Date: 7<sup>th</sup> October 2025  
Email: [REDACTED]@e-lindsey.gov.uk  
Our ref: B/25/0225  
Your ref: EN 010151

**Re: EN 010151 - Beacon Fen Energy Park – Section 90 Planning Act 2008.**

**Boston Borough Councils - Written Representation – Deadline One Submission - 7<sup>TH</sup> October 2025.**

© Copyright Reserved  
N:\ST19595-SOLAR PV\DCO BECKER FEN\03-DESIGN\AUTOCAD\ST19595-461-VEGETATION REMOVAL PLAN REV BECKER FEN SUBSTATION UPDATED.DWG

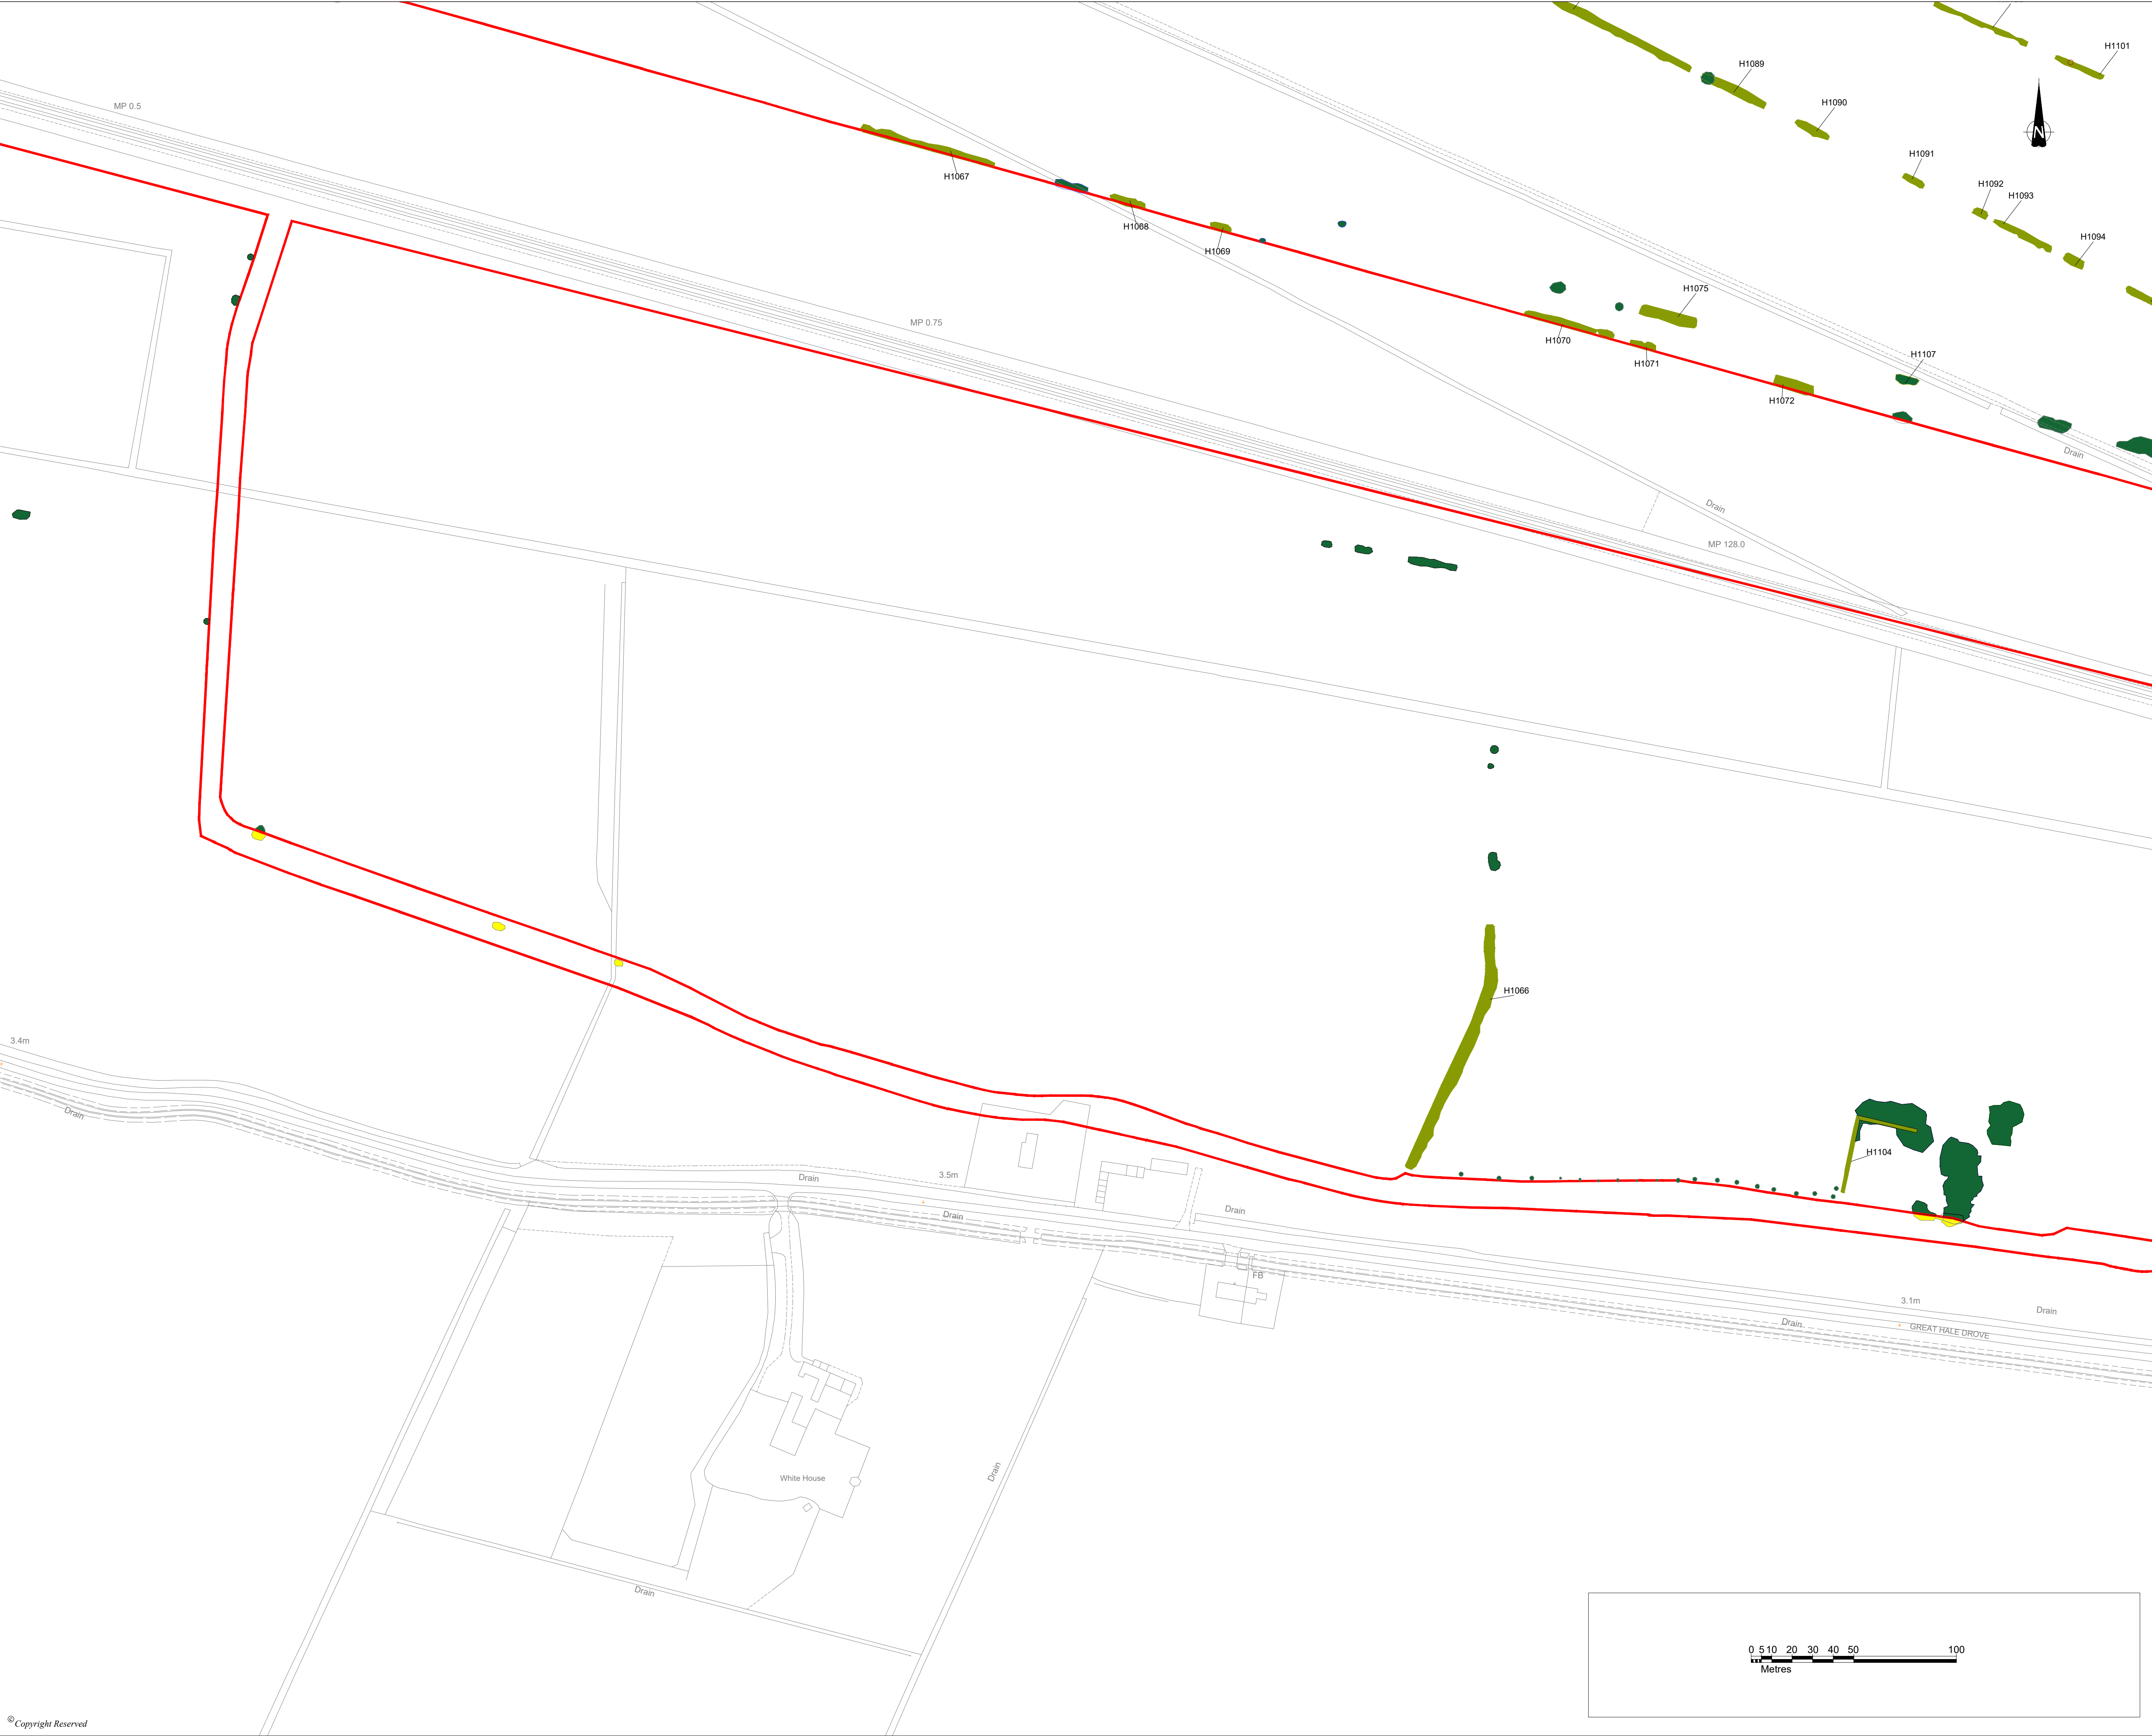
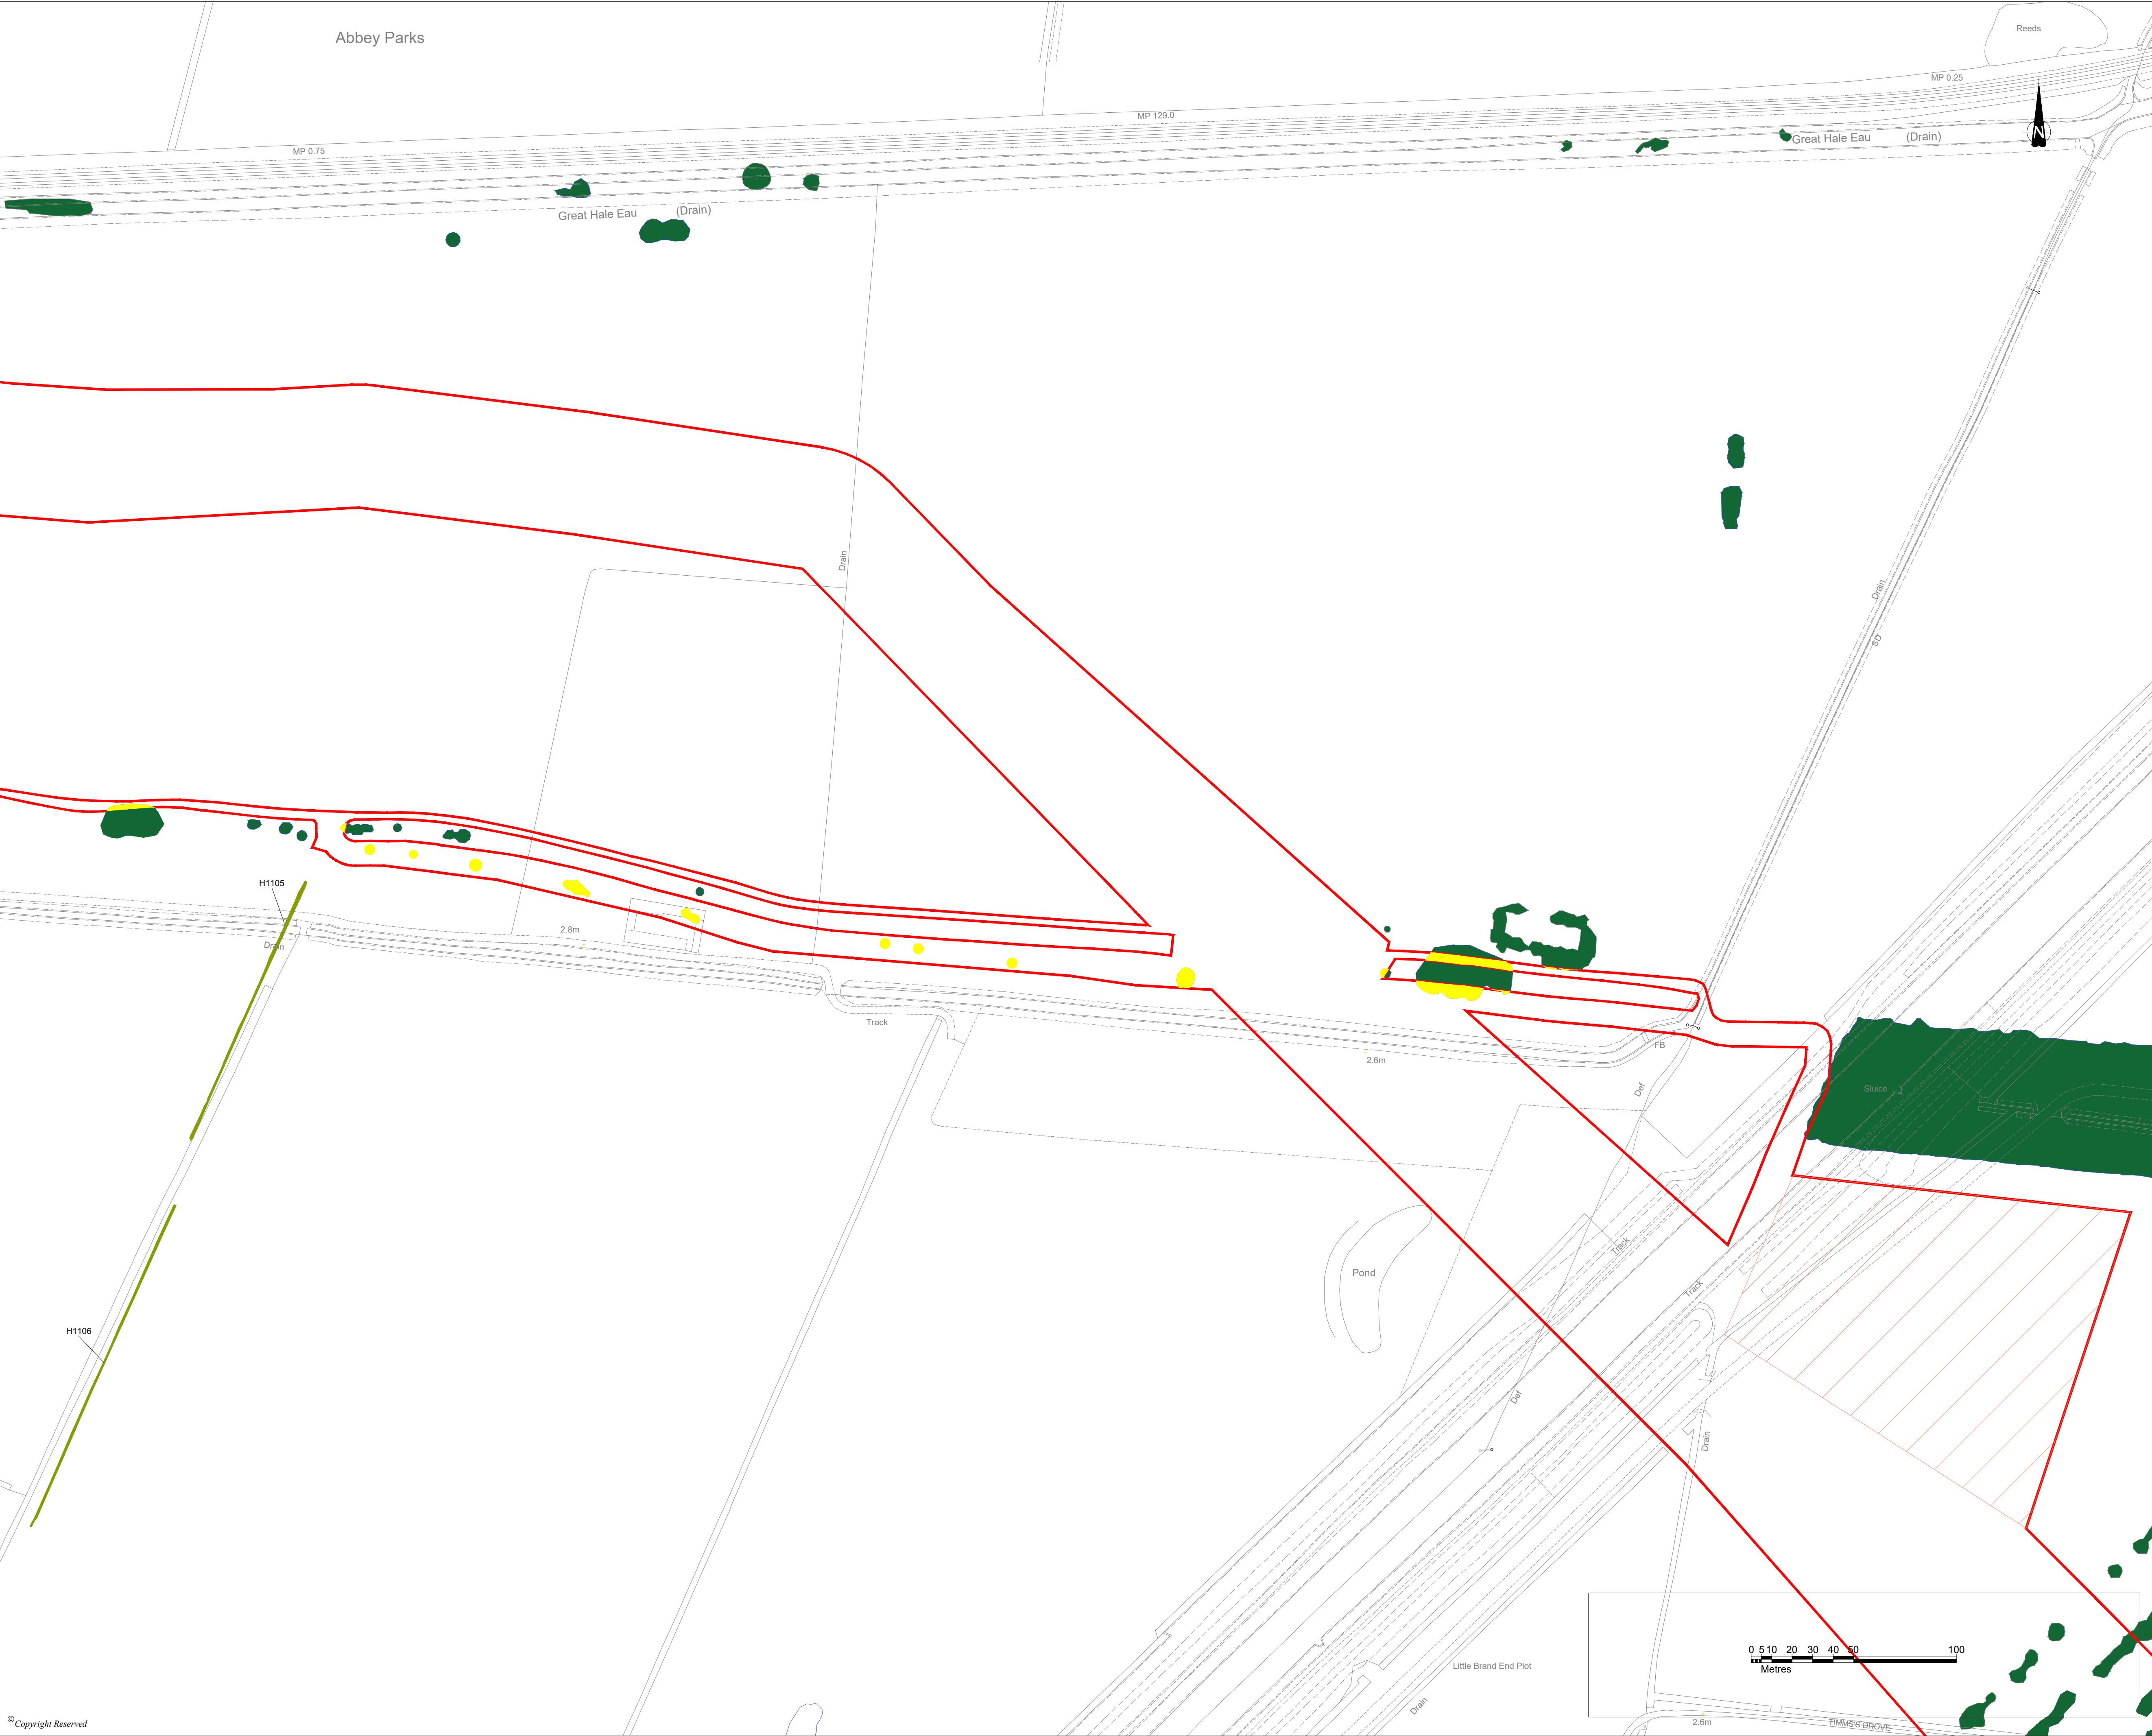
Vegetation Removal Plan 6.4.43c Fig 6.32 (APP-237) appears to show the potential removal of all vegetation within the LWS South Forty Foot Drain. The Borough do not understand why this is necessary, when the Applicant has committed too HDD crossing method (paragraph 2.8.3 of the Outline CEMP (APP-077)). The Applicant should provide Clarification on the Vegetation Removal Plans for South Forty Foot Drain and the commitment to use HDD trenchless crossing method at this location and how it is secured within the draft DCO .
